PLANNING CONSULTATION RESPONSE

Application No	2026/0641
Proposal	Residential development up to 9 dwellings (Permission in Principle).
Address	Land off Barnsley Road, Darton, Barnsley
Date of Consultation Reply	20/08/2026
Consultee	Highway Drainage

Drawing Title.
**SITE PLAN AS
PROPOSED
9NO DWELLINGS**

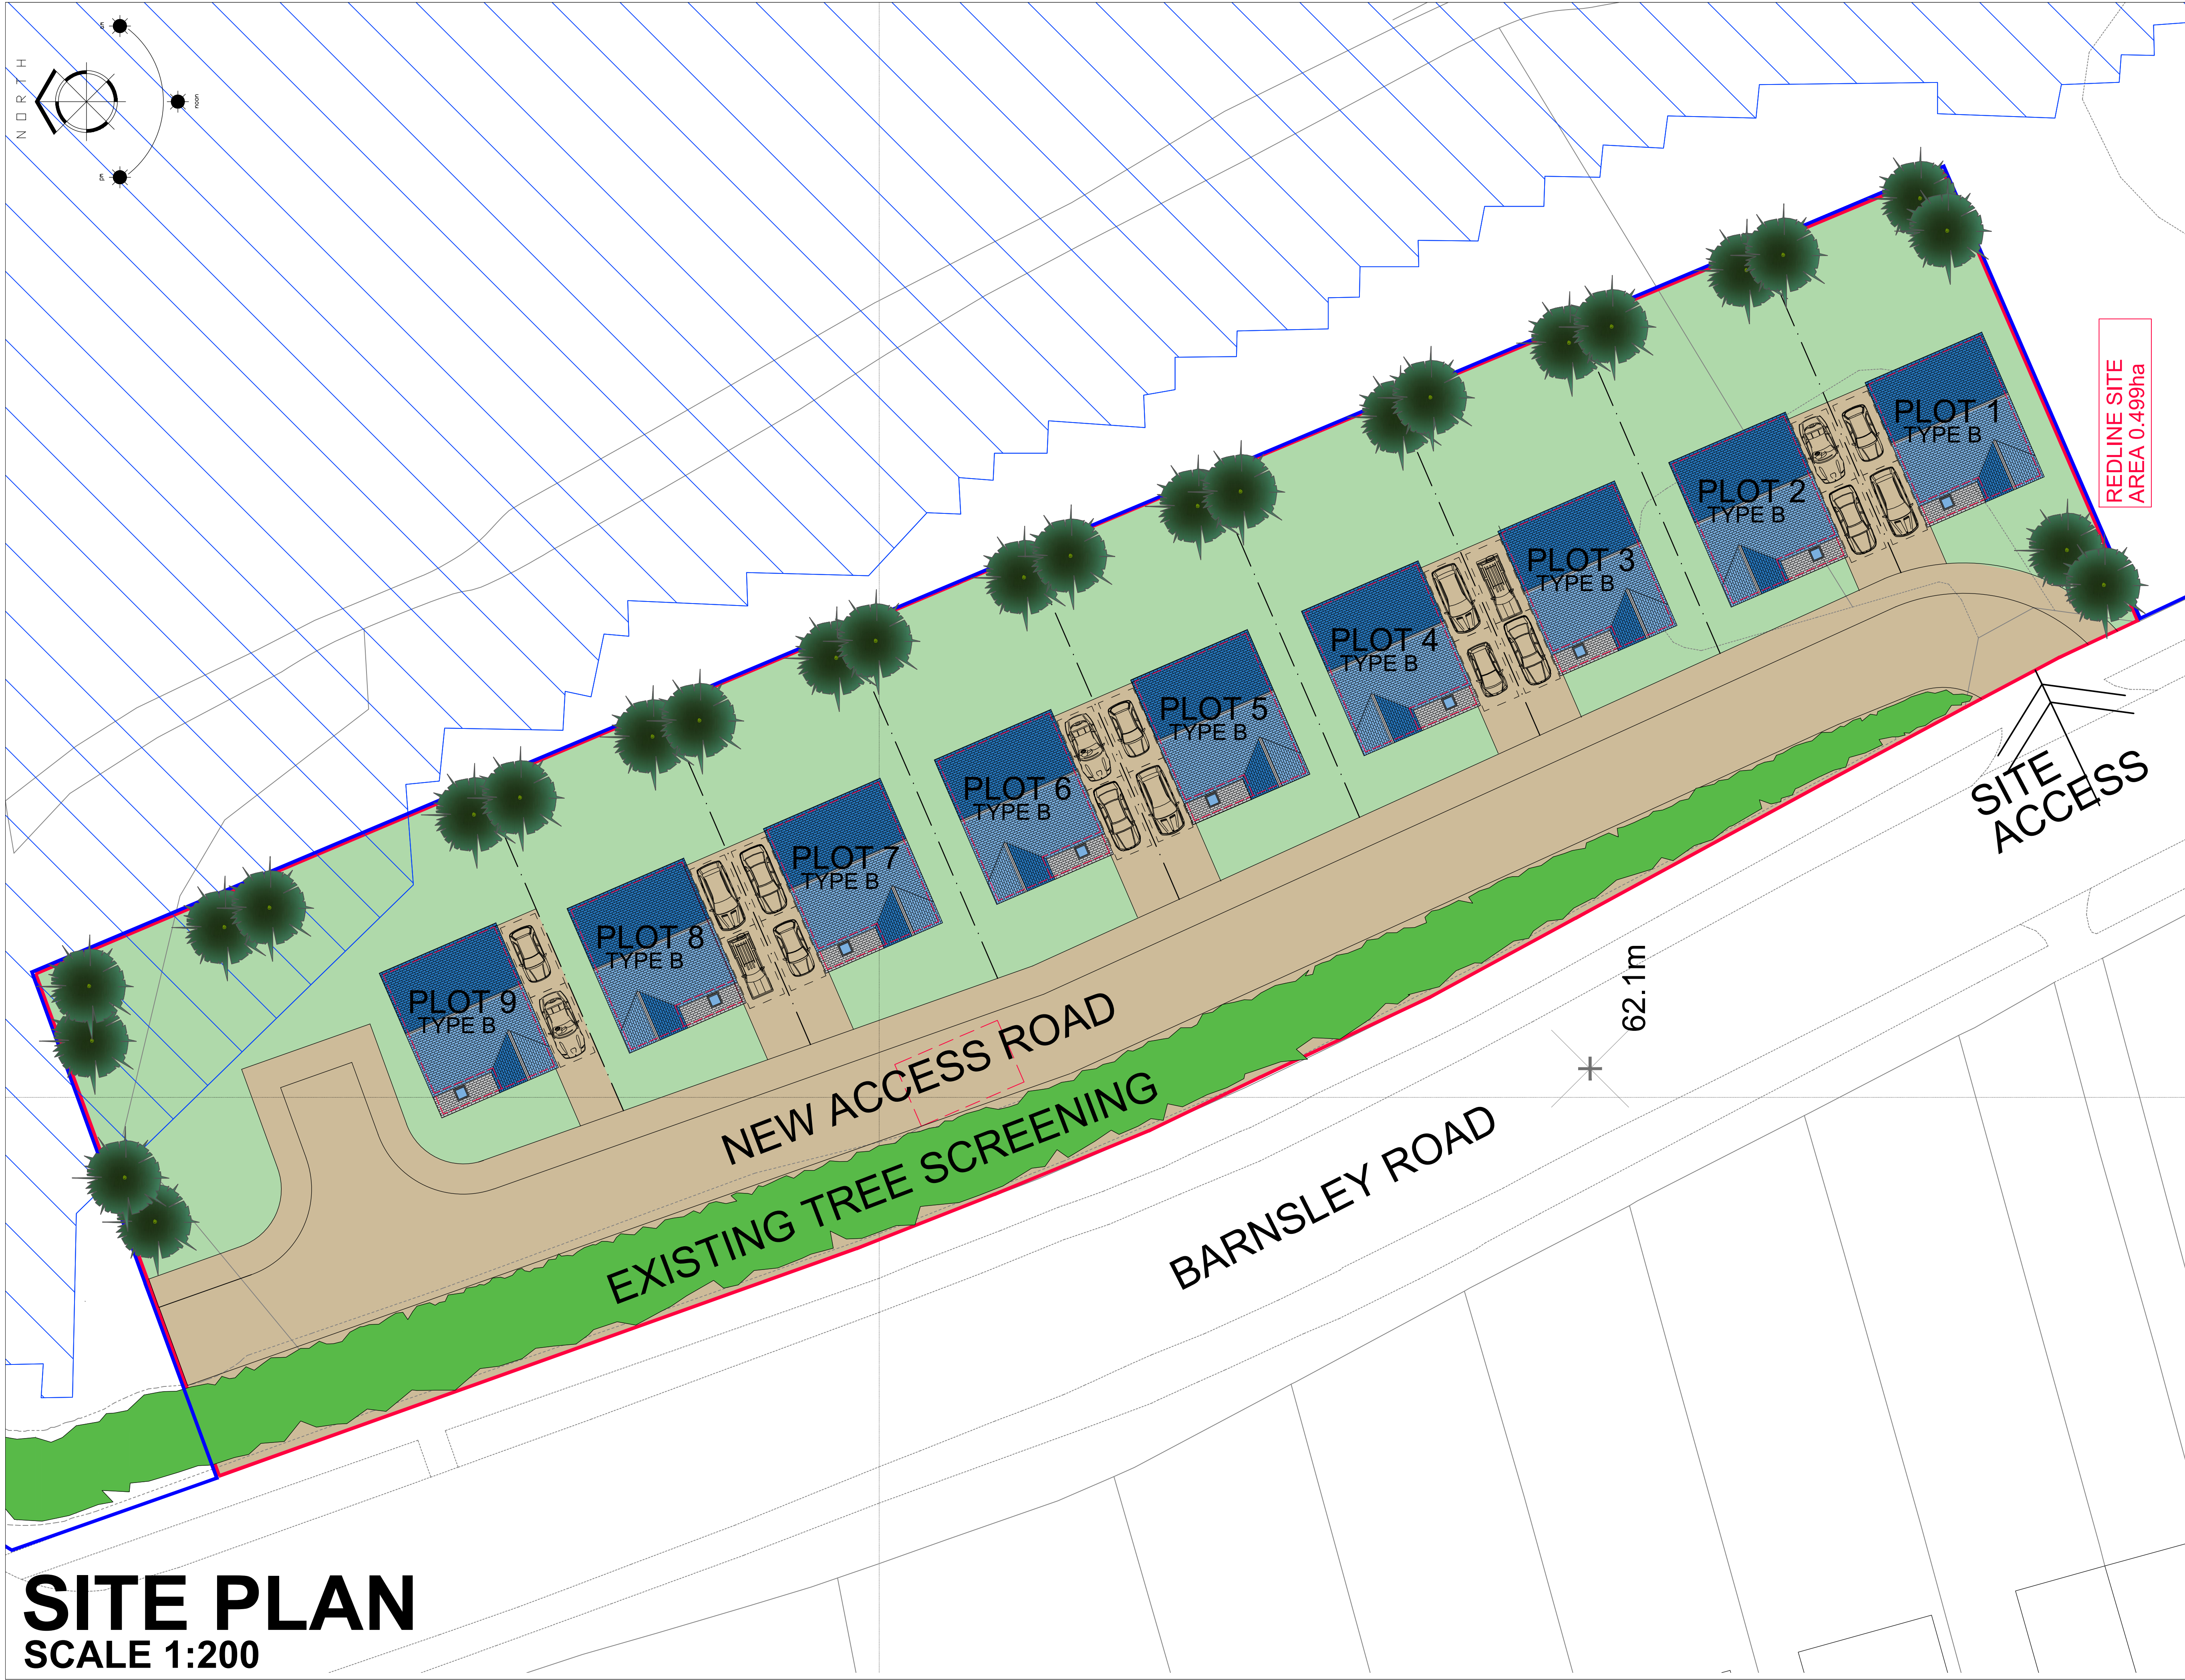
I refer to your memo dated 20th August 2026 and would inform you we have now examined the proposals submitted by JR Planning, and would request a Flood Risk Assessment due to part of the site appearing in Flood Zone 2
